# Defence Infrastructure Organisation

Application Ref: EN010130

12 June 2024

**PLANNING ACT 2008 - APPLICATION FOR DEVELOPMENT CONSENT GT R4 LIMITED,  
TRADING AS OUTER DOWSING OFFSHORE WIND. THE PROPOSED OUTER DOWSING  
OFFSHORE WIND FARM ORDER.**

Figure 16.1

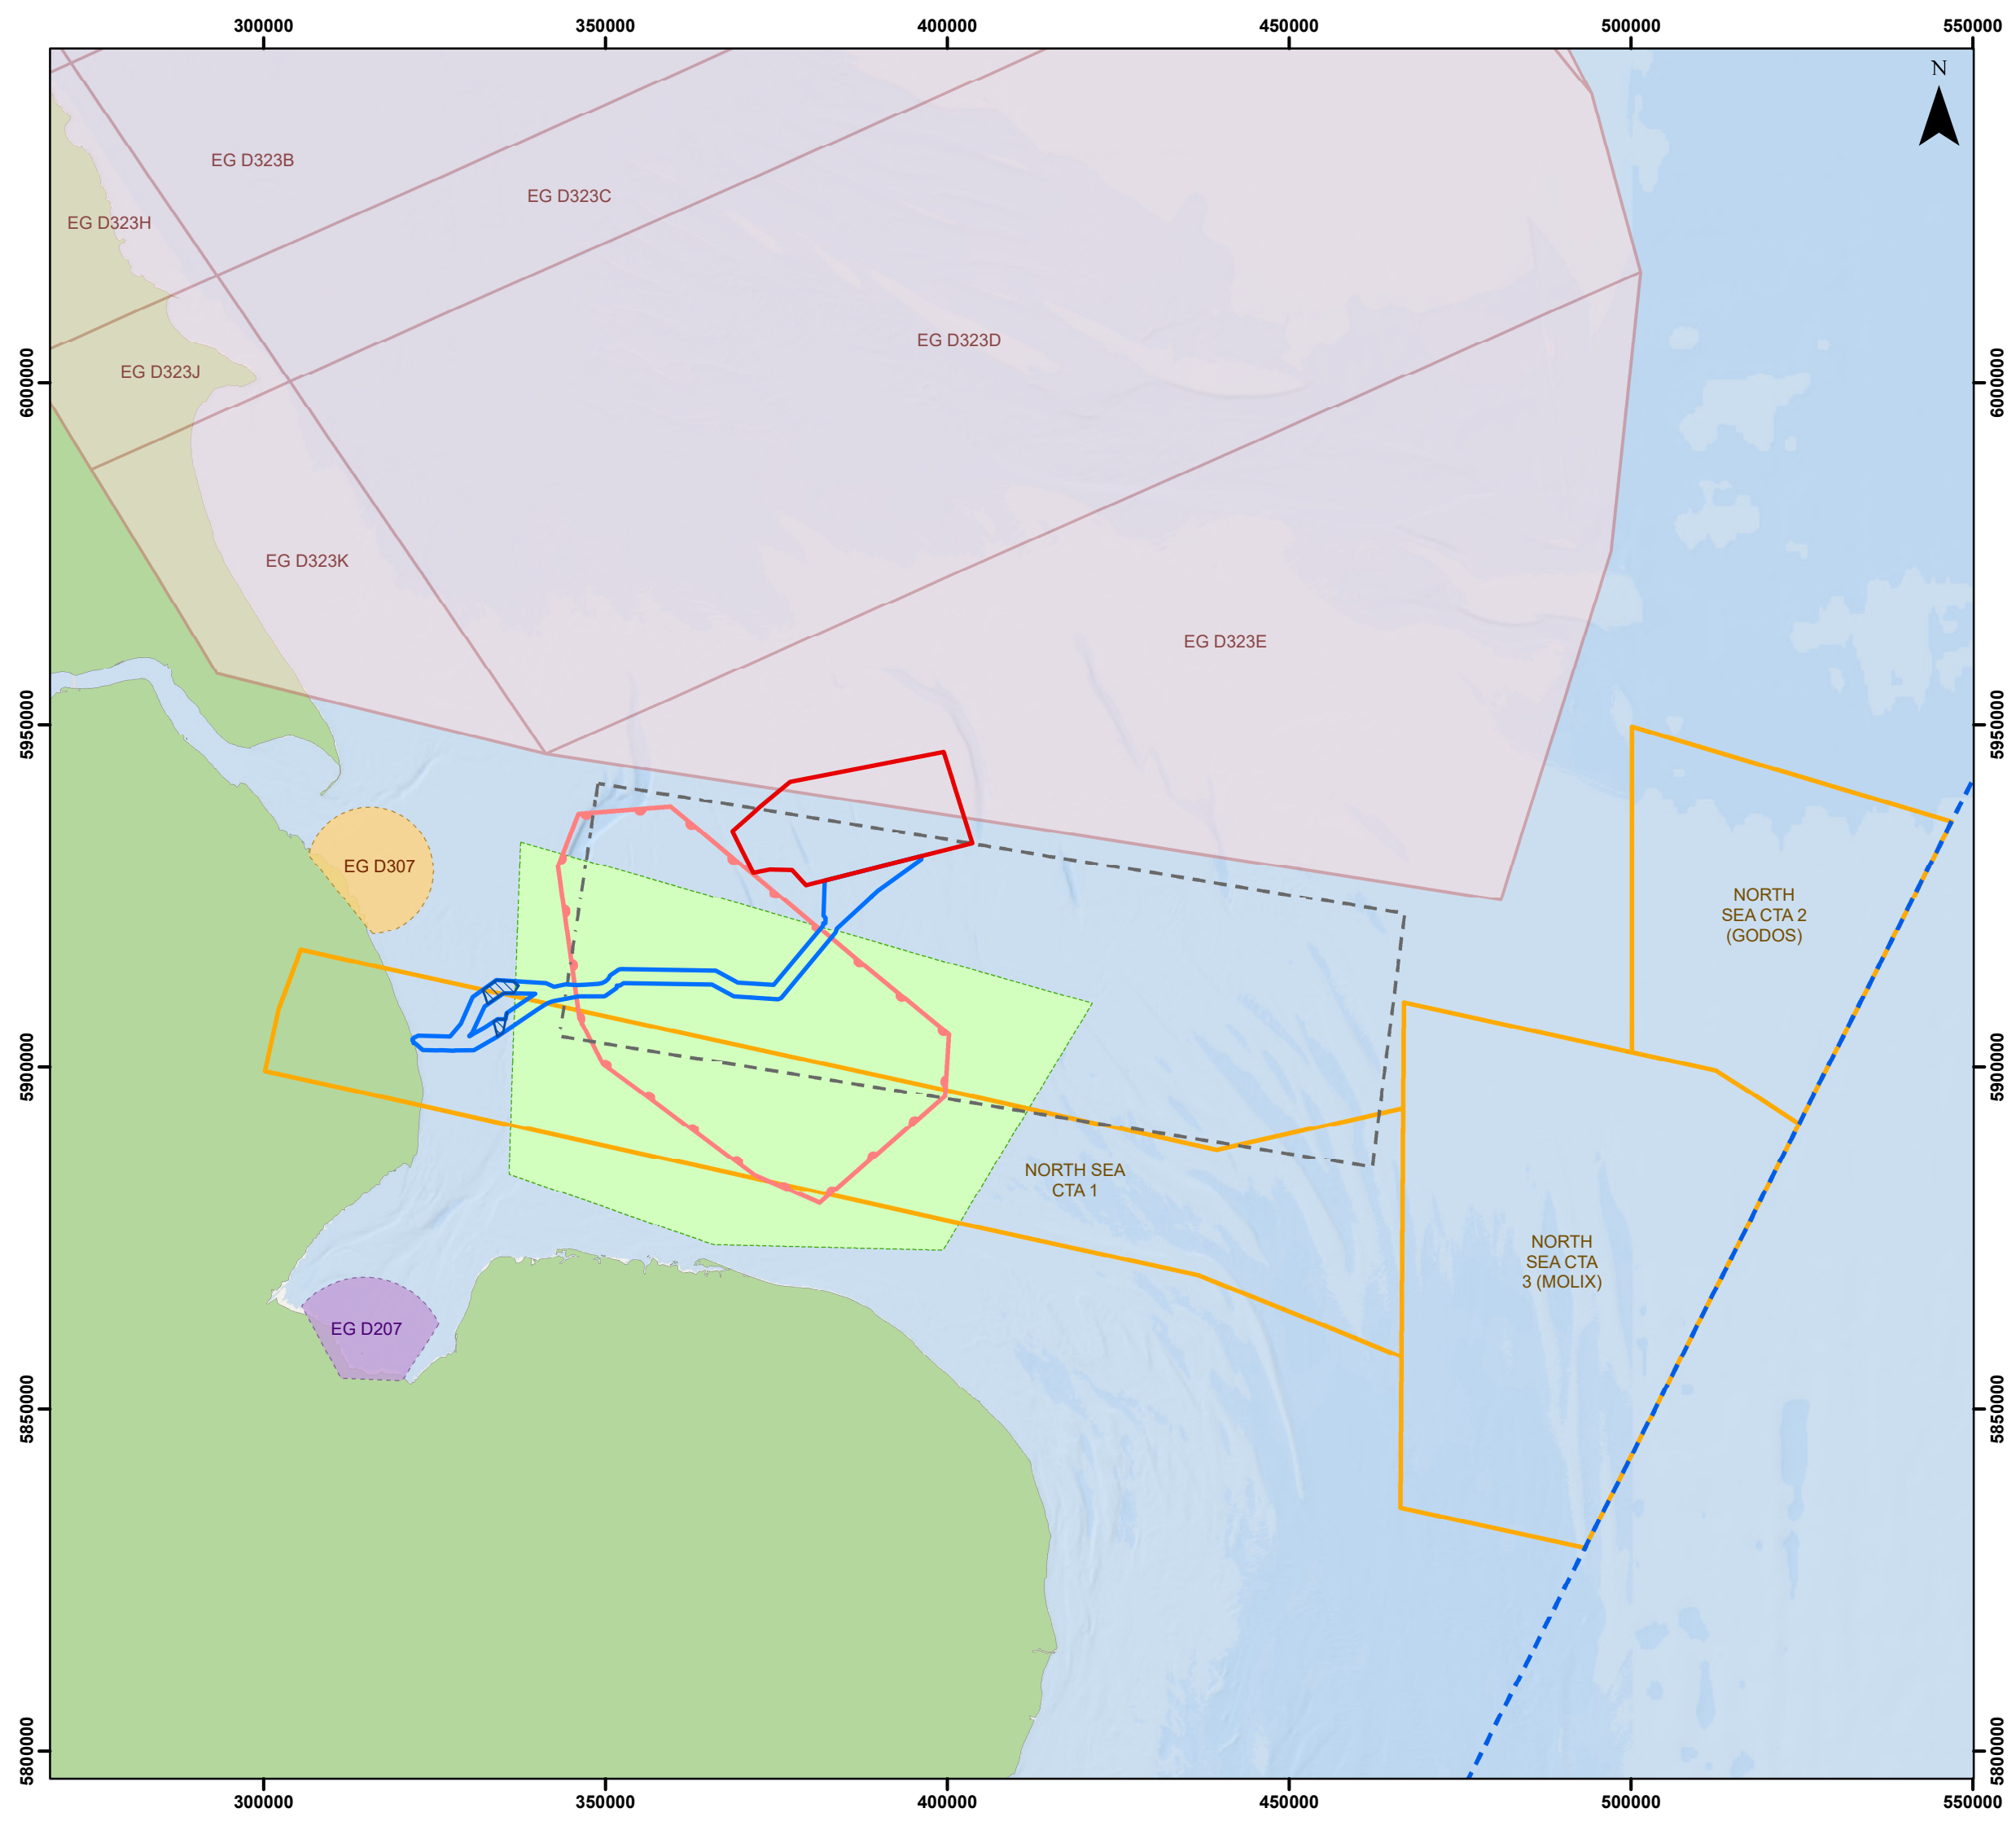
At this time the MOD must **object** to the proposed development on the basis that the scheme would have a significant and detrimental impact on the effective operation and capability of air defence radars deployed at Remote Radar Head (RRH) Neatishead and RRH Staxton Wold.

The proposed turbines would be located approximately 86.8km from, detectable by, and will cause unacceptable interference to the AD radar at RRH Neatishead and approximately 119.4km from, detectable by, and will cause unacceptable interference to the ASD radar at RRH Staxton Wold.

Our assessments have determined that, when operational, the proposed wind farm will cause unacceptable and unmanageable interference to the effective operation of air defence radar deployed at RRH Neatishead and RRH Staxton Wold.

The need to mitigate the impacts of the proposed development upon the effective operation of RRH Neatishead and RRH Staxton Wold has been recognised by the applicant and are set out in Chapter 16: Aviation, Radar, Military and Communications of the Offshore Environmental Statement (March 2024). Whilst the applicant has indicated the need to mitigate these impacts, to date no mitigation scheme has been submitted for assessment.

Therefore, on the basis of the information provided, and until a suitable mitigation scheme has been submitted, assessed, and accepted, the MOD must **object** to this proposal due to the impact it will have on the AD radars at both RRH Neatishead and RRH Staxton Wold.

Environmental Statement  
 Existing Airspace Environment  
 Figure 16.2

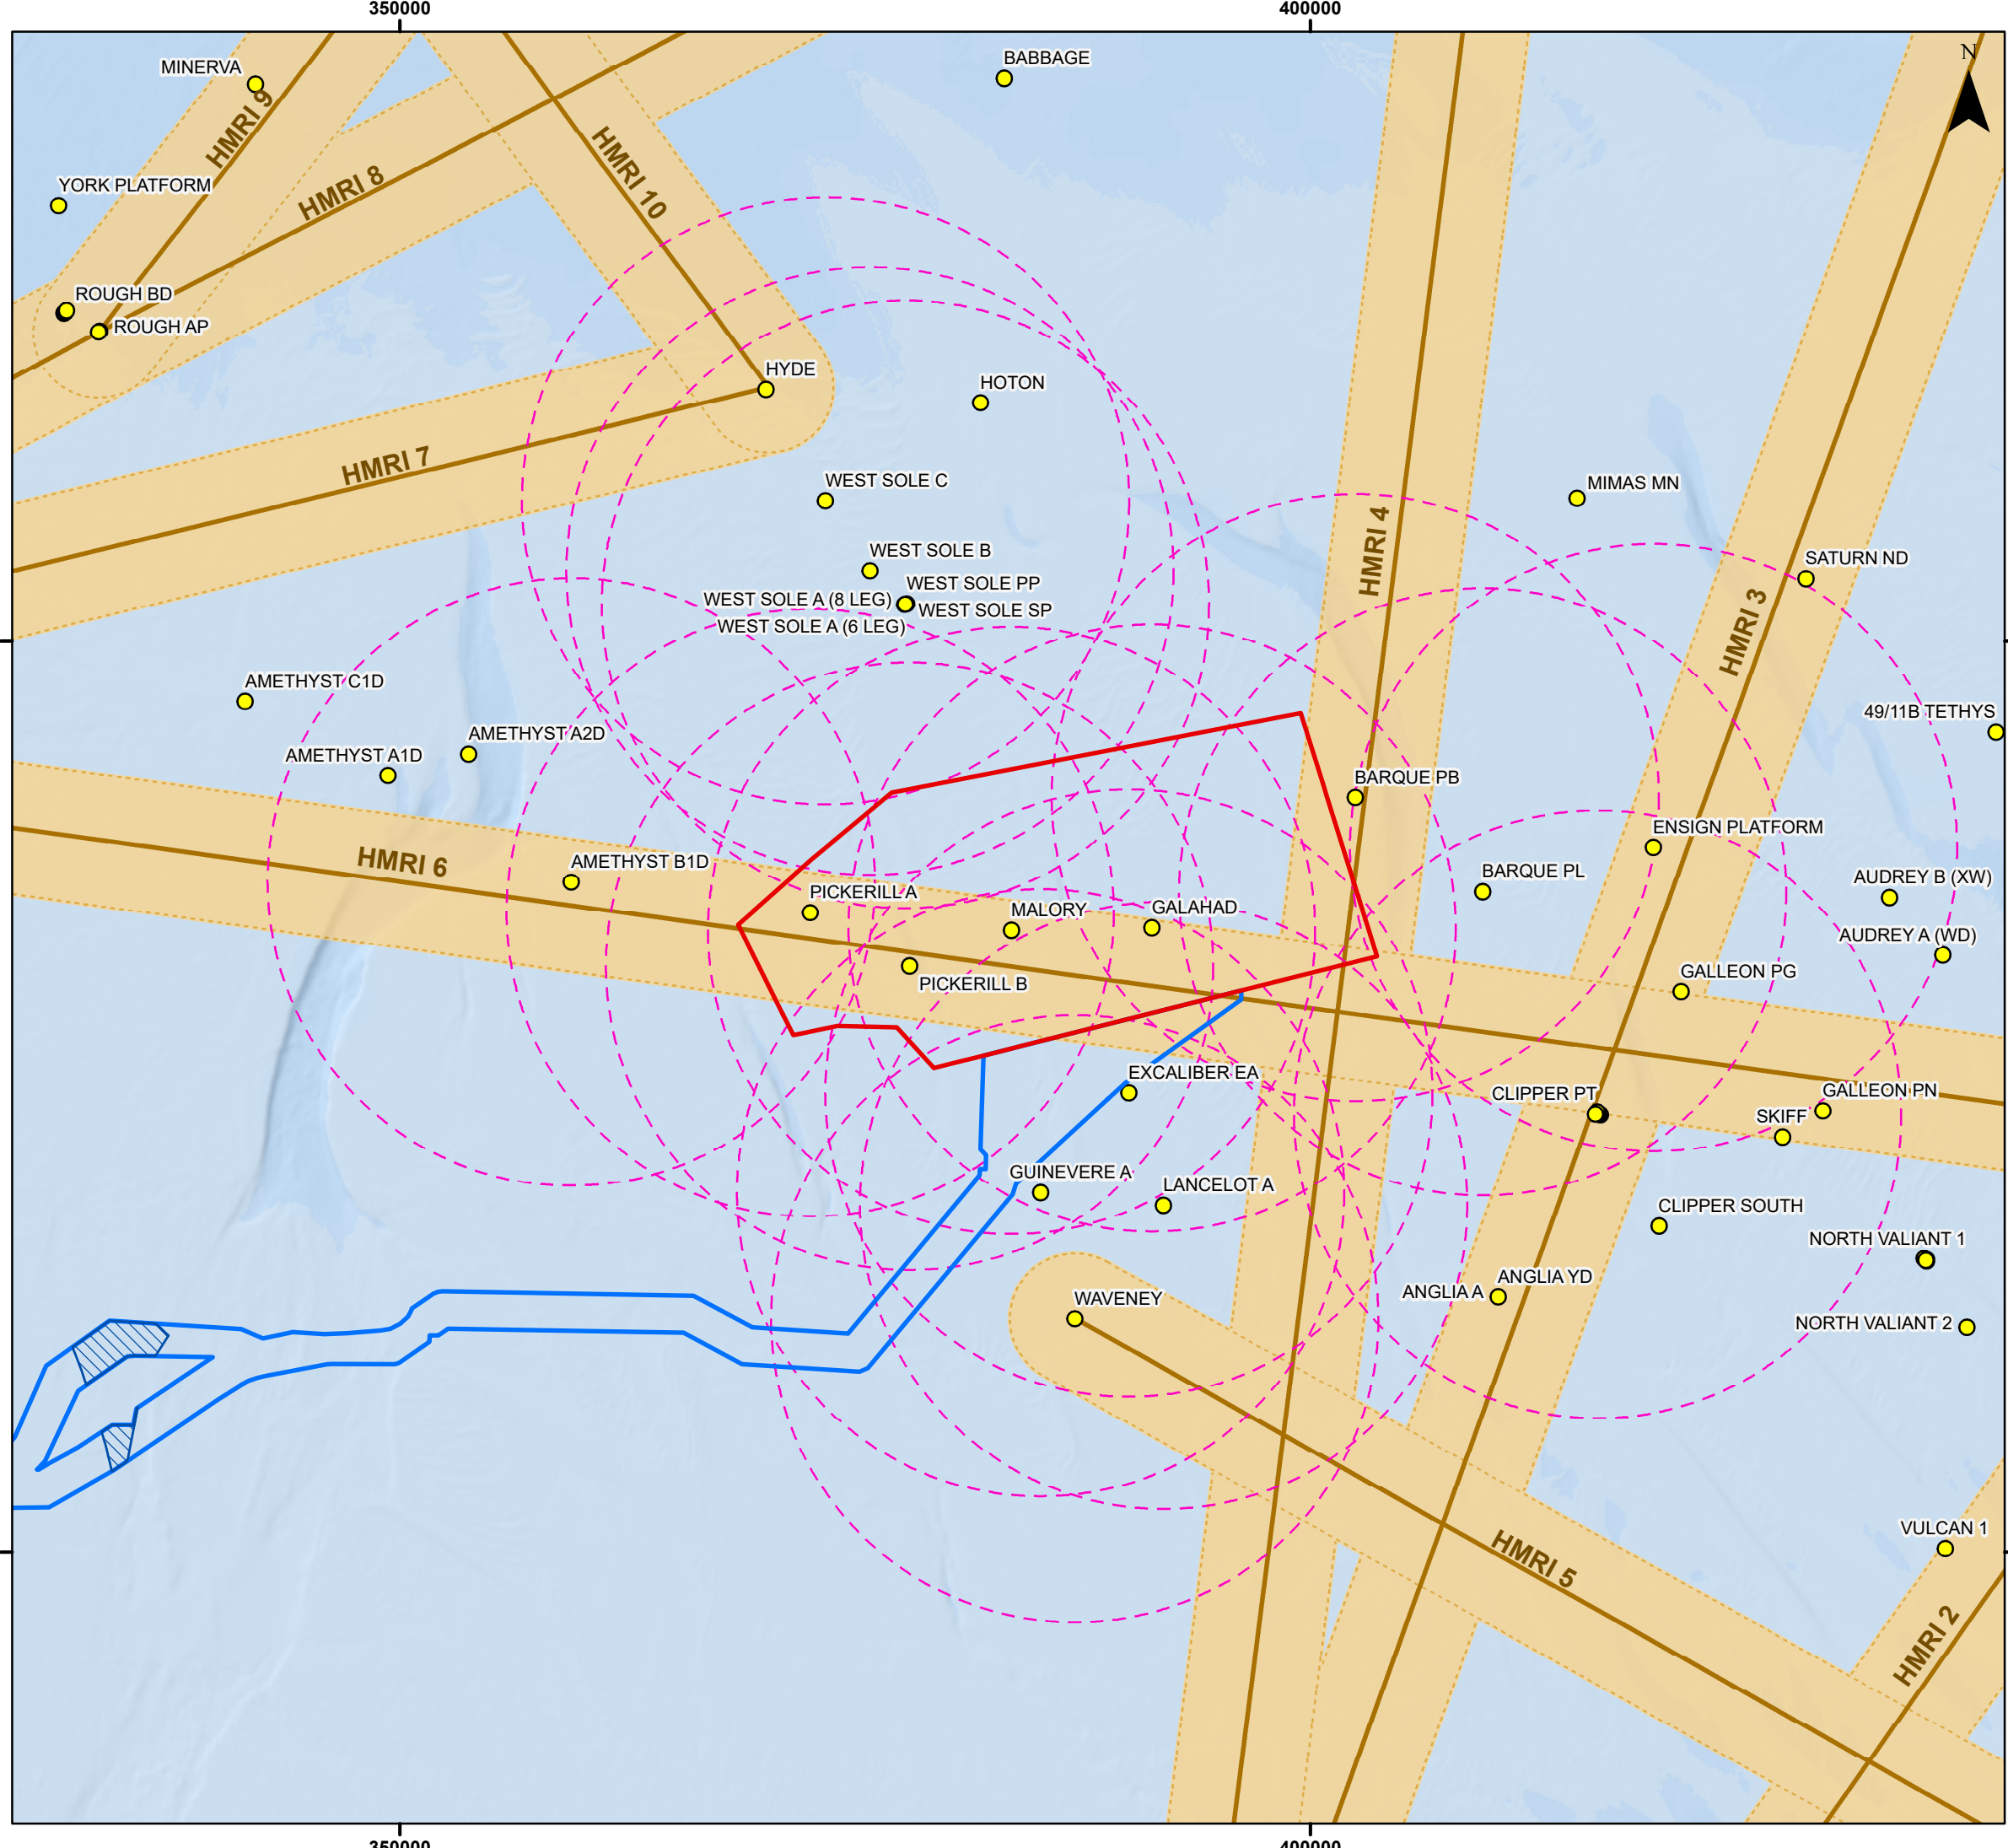
In this case the development falls within Low Flying Area 11 (LFA 11). Within these areas fixed wing aircraft may operate as low as 250 feet or 76.2 metres above ground level to conduct low level flight training. The addition of turbines in this location would introduce a physical obstruction to low flying aircraft operating in the area.

In the event that the applicant is able to overcome the objections listed above, MOD would require that conditions are added to any consent issued requiring the submission, approval and implementation of an aviation lighting scheme, and that sufficient data is submitted to ensure that structures can be accurately charted to allow deconfliction. The applicant has acknowledged the MOD requirement for MOD accredited aviation safety lighting in table 16.2 in Chapter 16, Aviation, Radar, Military and Communications of the Offshore Environmental Statement (March 2024).

As this development includes structures that exceed a height of 60m above Highest Astronomical Tide (HAT) it would be subject to the lighting requirements set out in the Air Navigation Order 2016. In addition to any CAA requirements, the MOD will require the submission, approval, and implementation of an aviation safety lighting specification that details the installation of MOD accredited aviation safety lighting.
